Re: Objection to MP08_0244 MOD 1 Modification Request for Mixed Used Development at 23-37 Lindfield Avenue and 11 Havilah Lane, Lindfield

Major Projects Assessment
Department of Planning and Infrastructure
GPO Box 39, SYDNEY, NSW 2001

3 SHADOW DIAGRAM - 21stDEC_3PM
5003 SCALE1 : 650

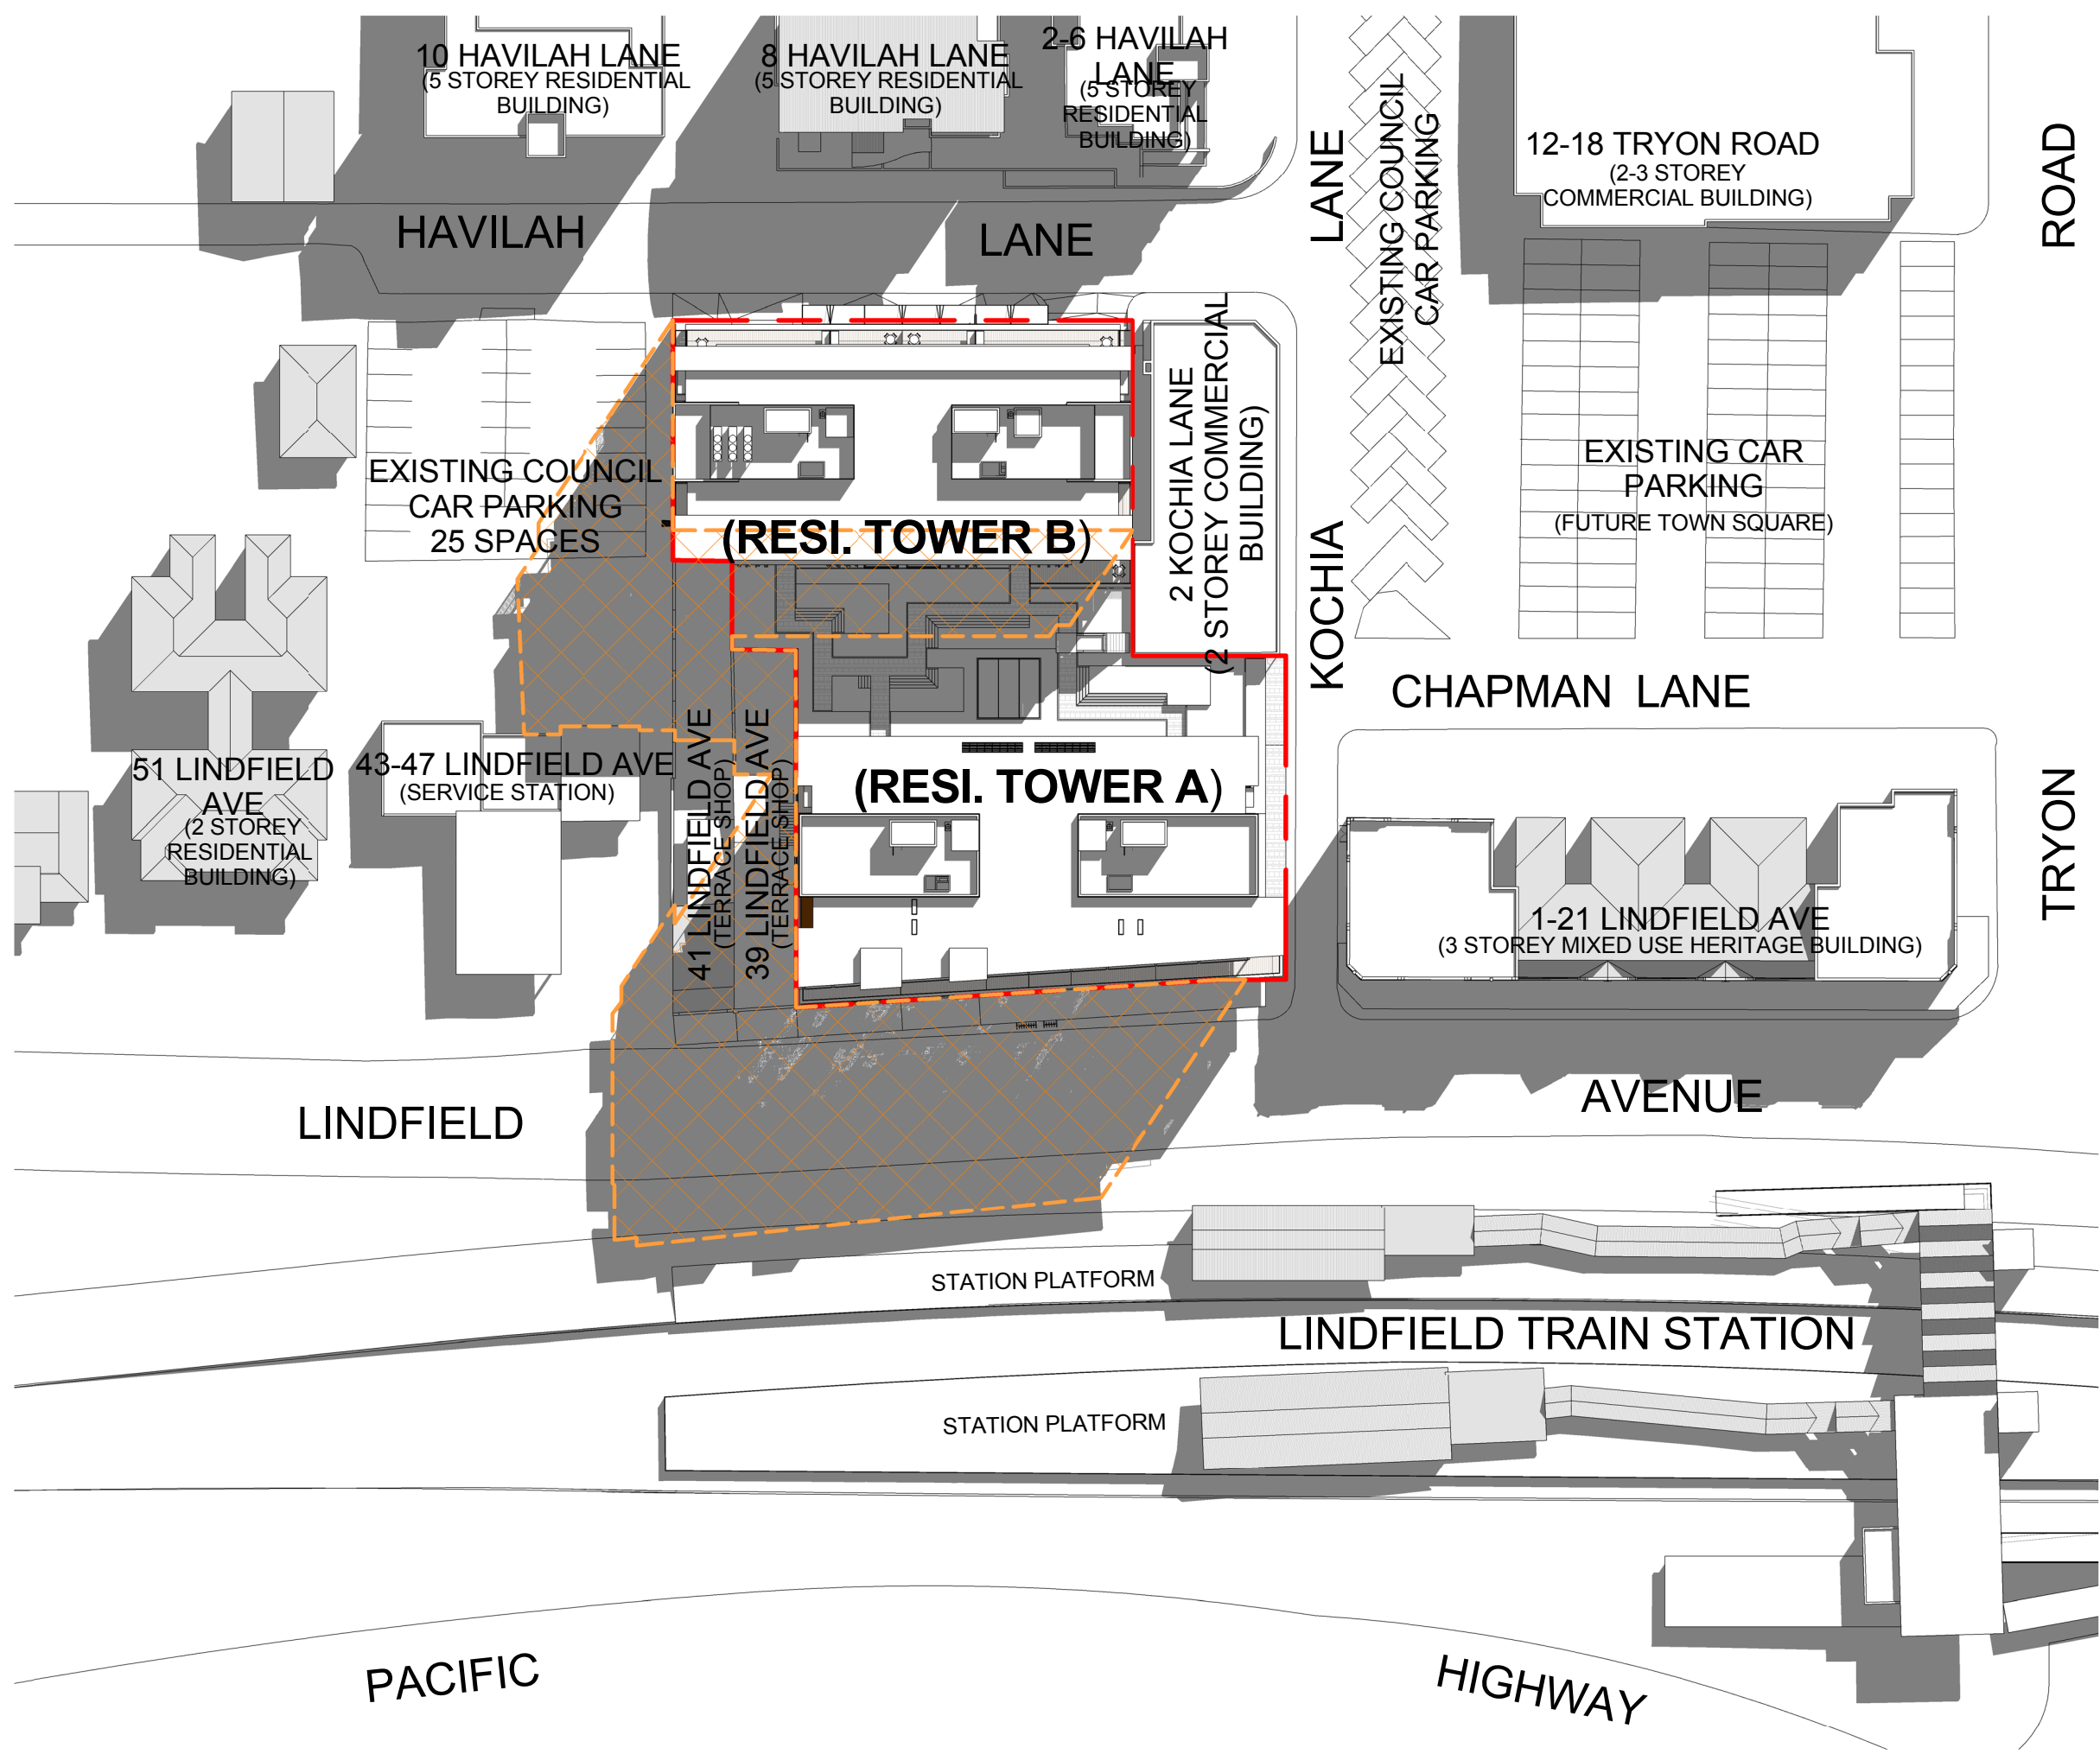
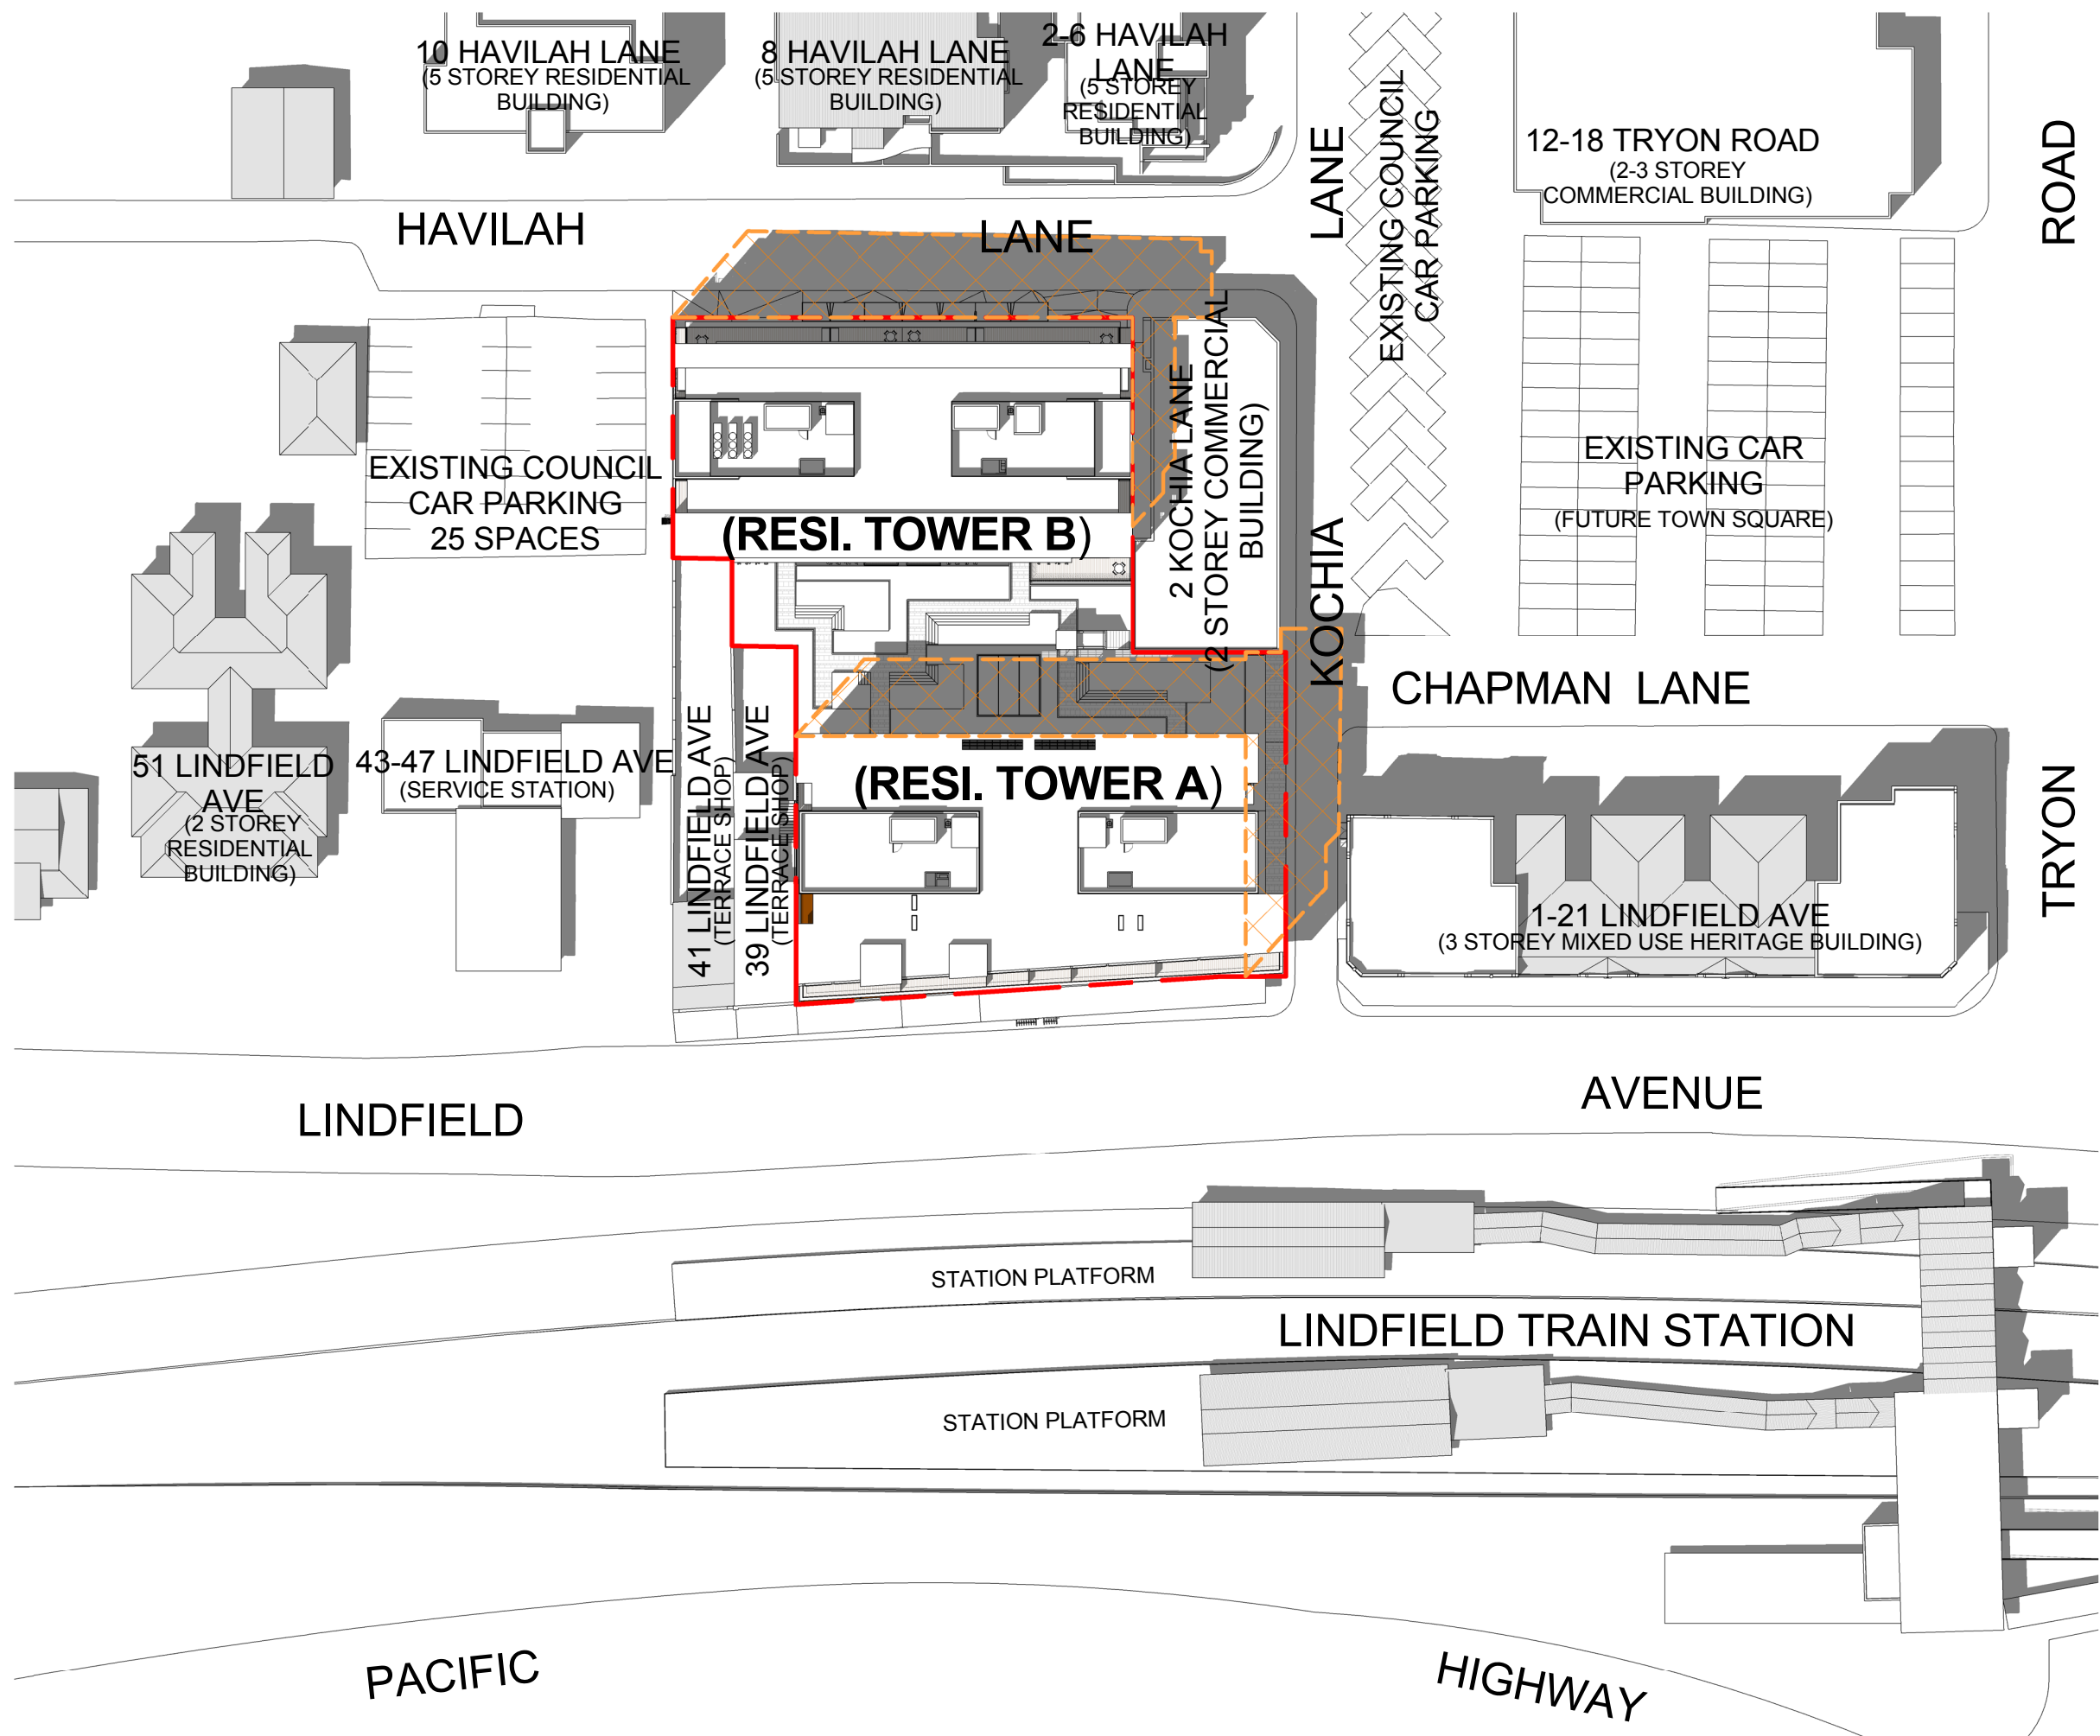
- The additional storeys create new adverse shadowing: a) for residents in the Havilah Lane apartments, particularly after 3pm b) for the popular outdoor café and central Lindfield hub area at 12 Tryon Road in afternoons, particularly in winter and c) for all commuters on the city bound Lindfield rail platform, instead of 50% of the year as approved, it will now be in shadow in the mornings 75% of the year
